Tel: 01903 737756
Email: planning@arun.gov.uk
www.arun.gov.uk/planning
Please ask for: Ms Iqraa Malik
Email: iqraa.malik@terraquest.co.uk
Telephone: 0121 234 1390
Our Ref: EP/22/26/HH
Your Ref:
Date: 5th March 2026

Application for Planning Permission for Works or Extension to a Dwelling

Development: Erection of a single storey extension on the rear elevation.
Location: 73 The Ridings East Preston BN16 2TW

Proposed site plan

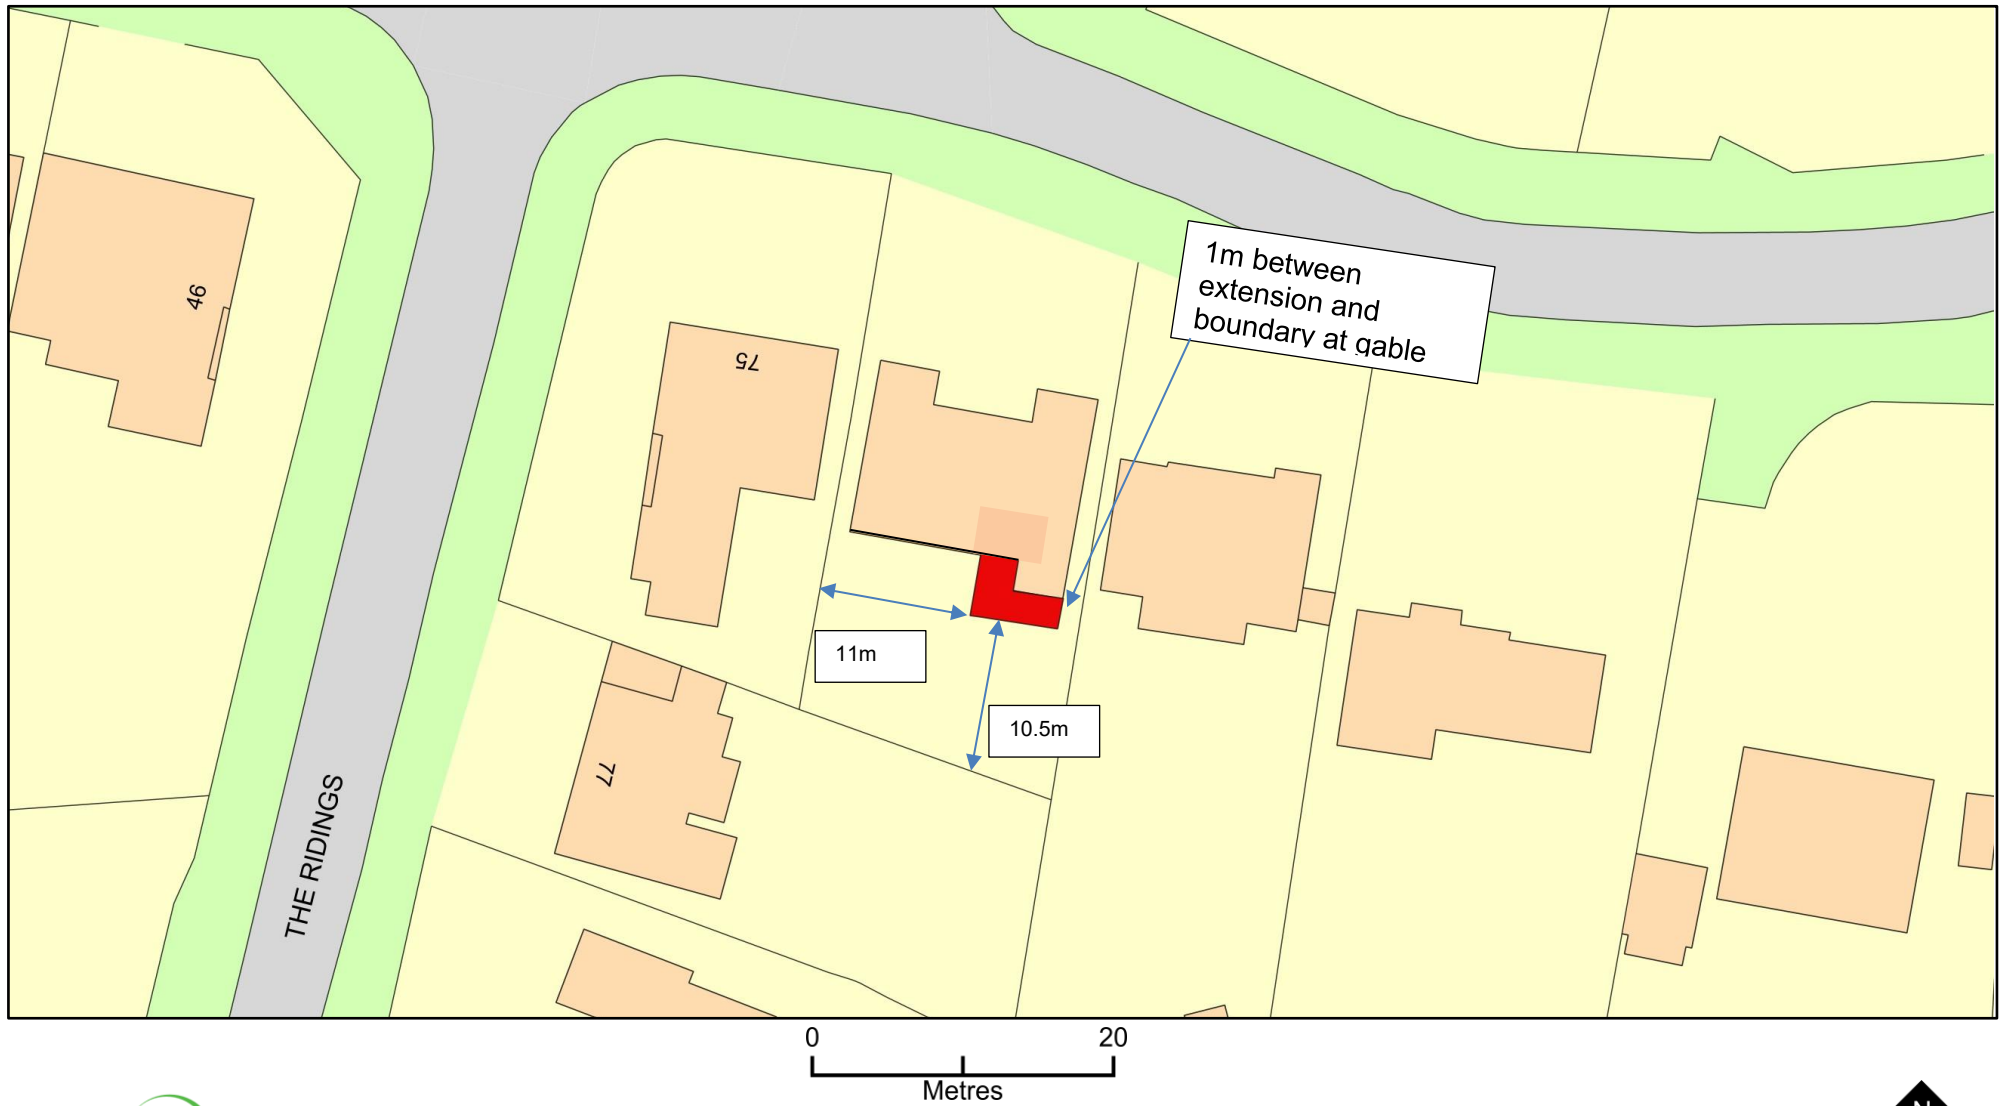
The extension has been shown incorrectly on the block plan, please review and amend.

In addition to the above, you are required to have dimensions from the proposed extension(s) to all site boundaries. Please amend.
